SPRINGS AT WATERVIEW  
DRAINAGE LETTER  
EL PASO COUNTY, COLORADO

August 2020

PCD No. SP-16-005  
PCD No. SF-16-017

FIGURE 5

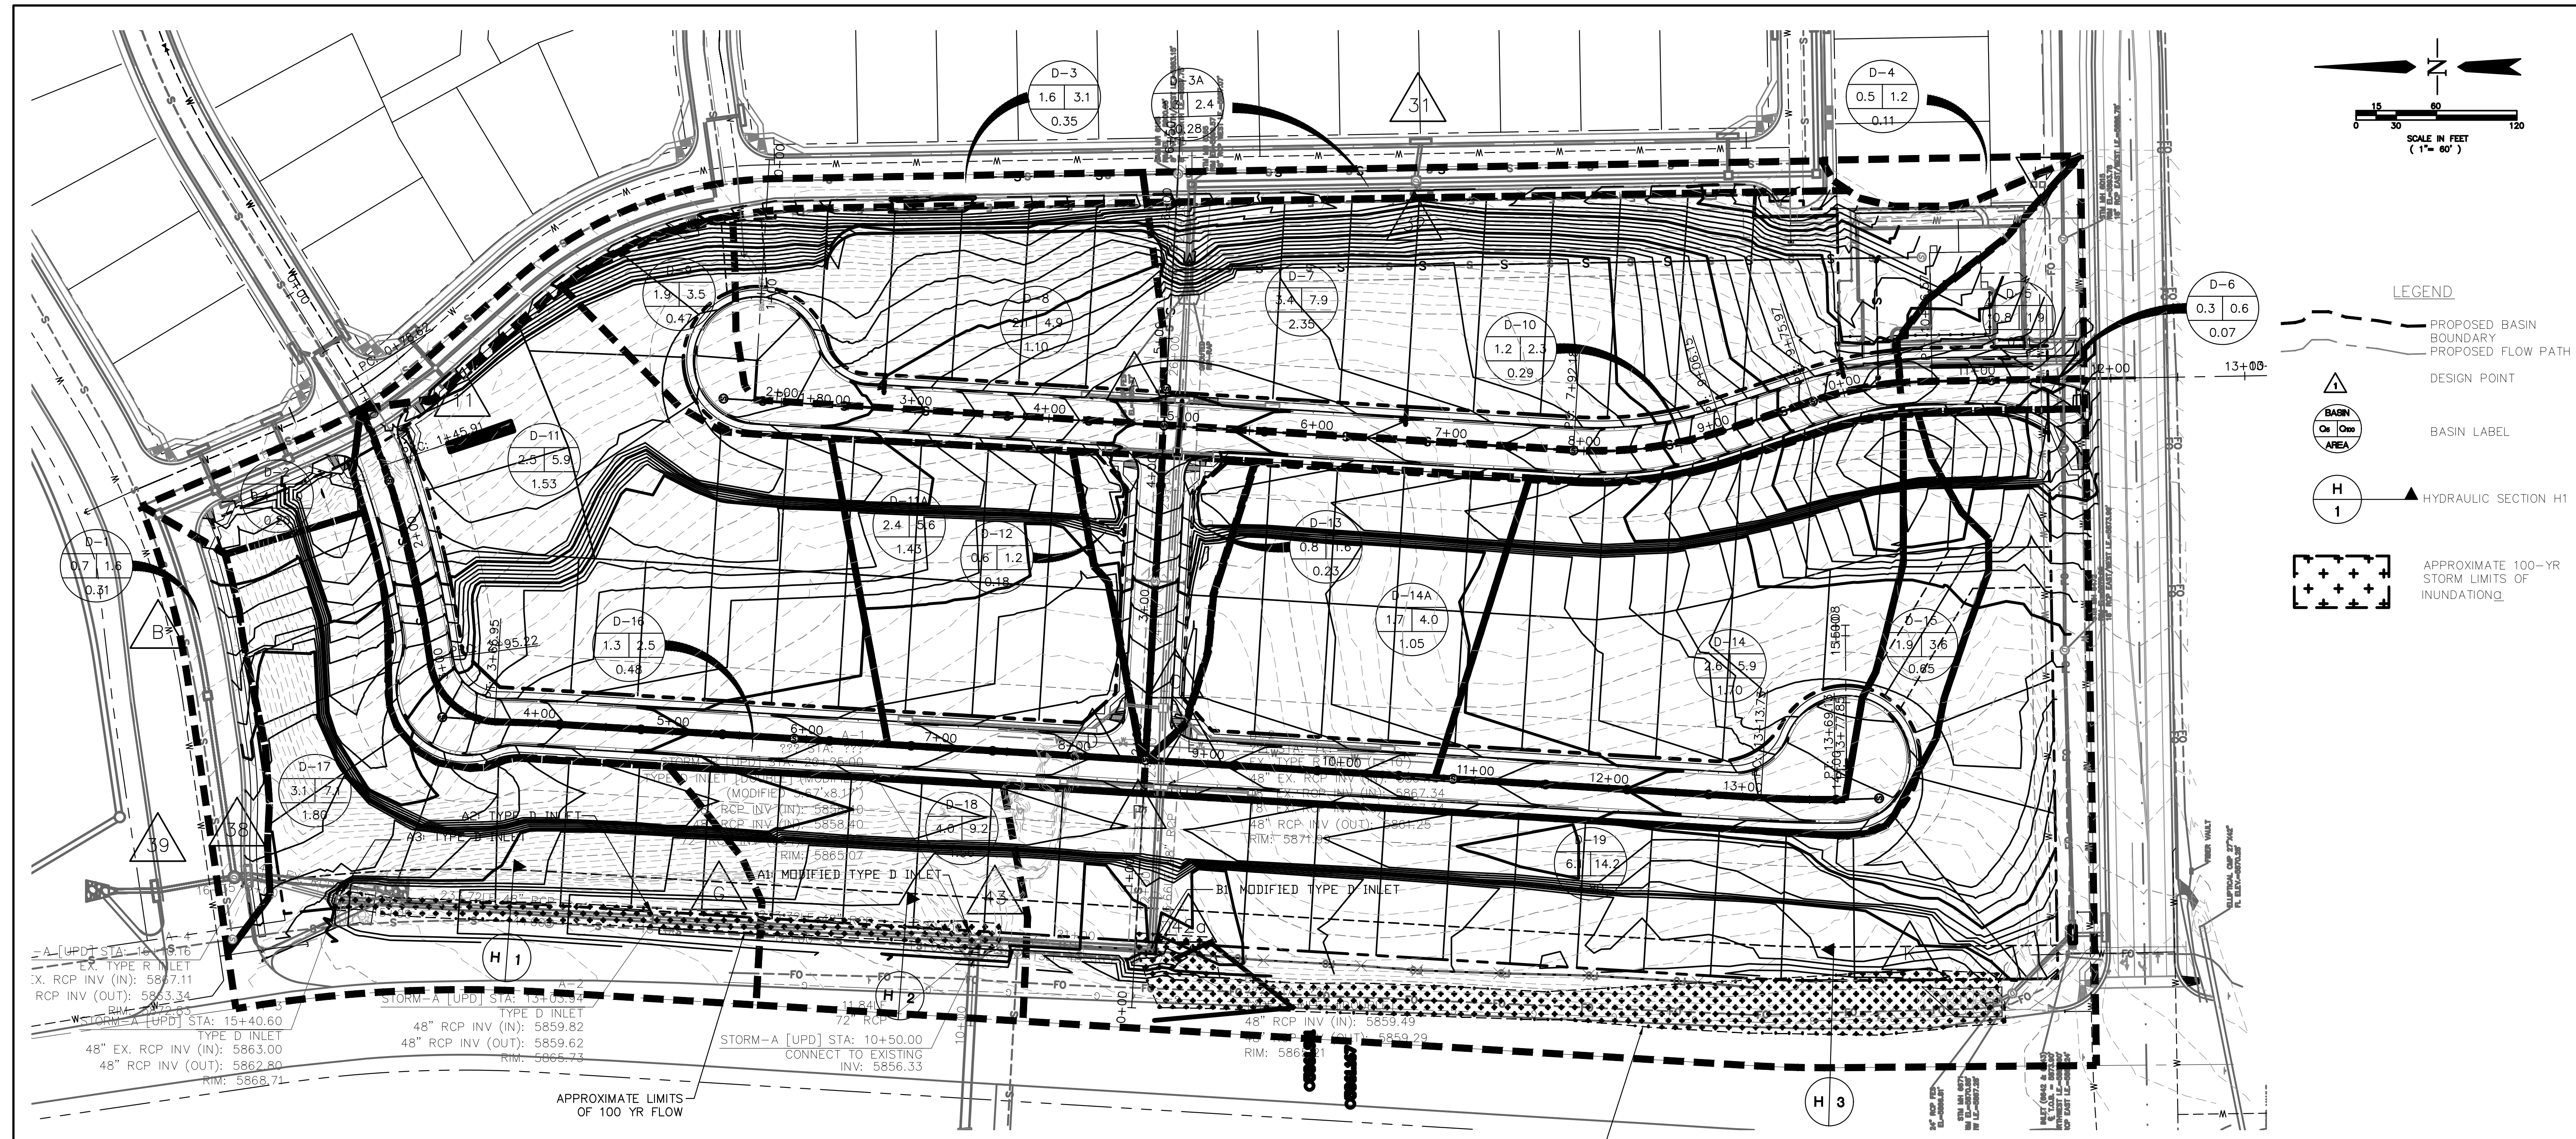
The limits of inundation is greater than what the approved drainage report indicated.

the Grinnell Boulevard roadside ditch to drain to the drainage easement and be collected in a Type D Update the grading modifications on the construction plans and the resulting inundation. See DCM Table 6-1 for allowable spread.

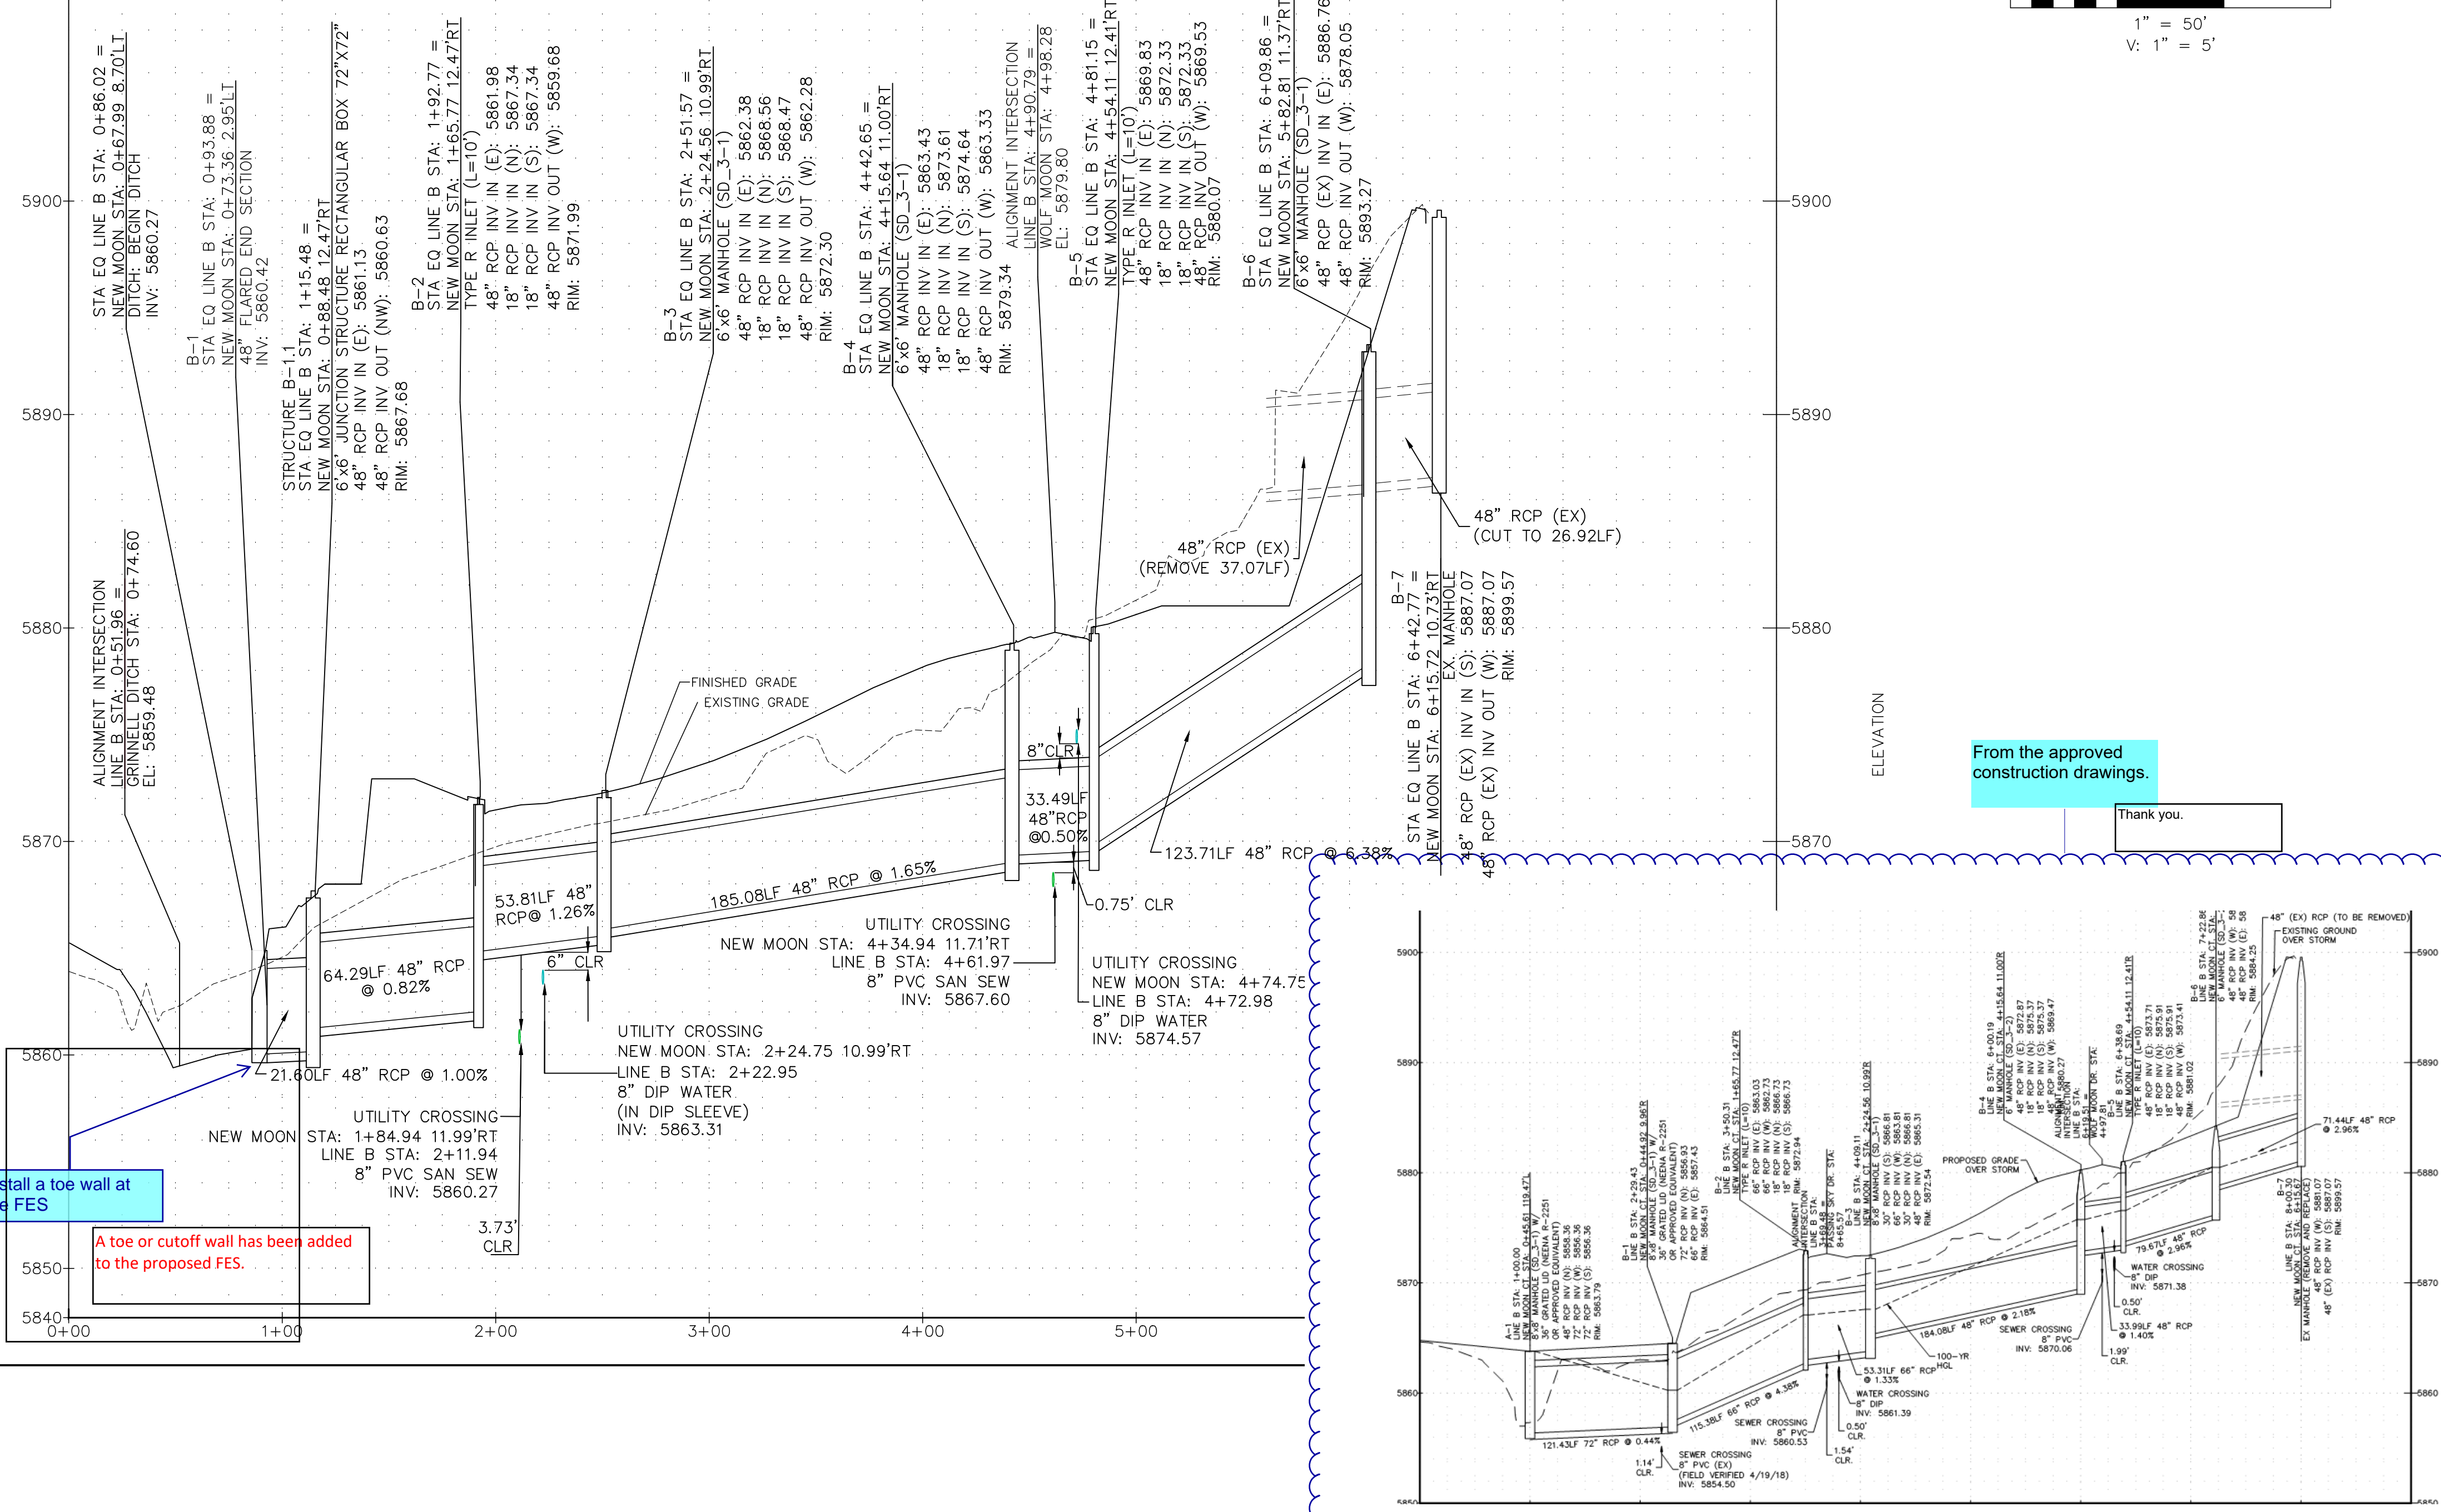
Clarify. Is this Stormline B on the construction plans?
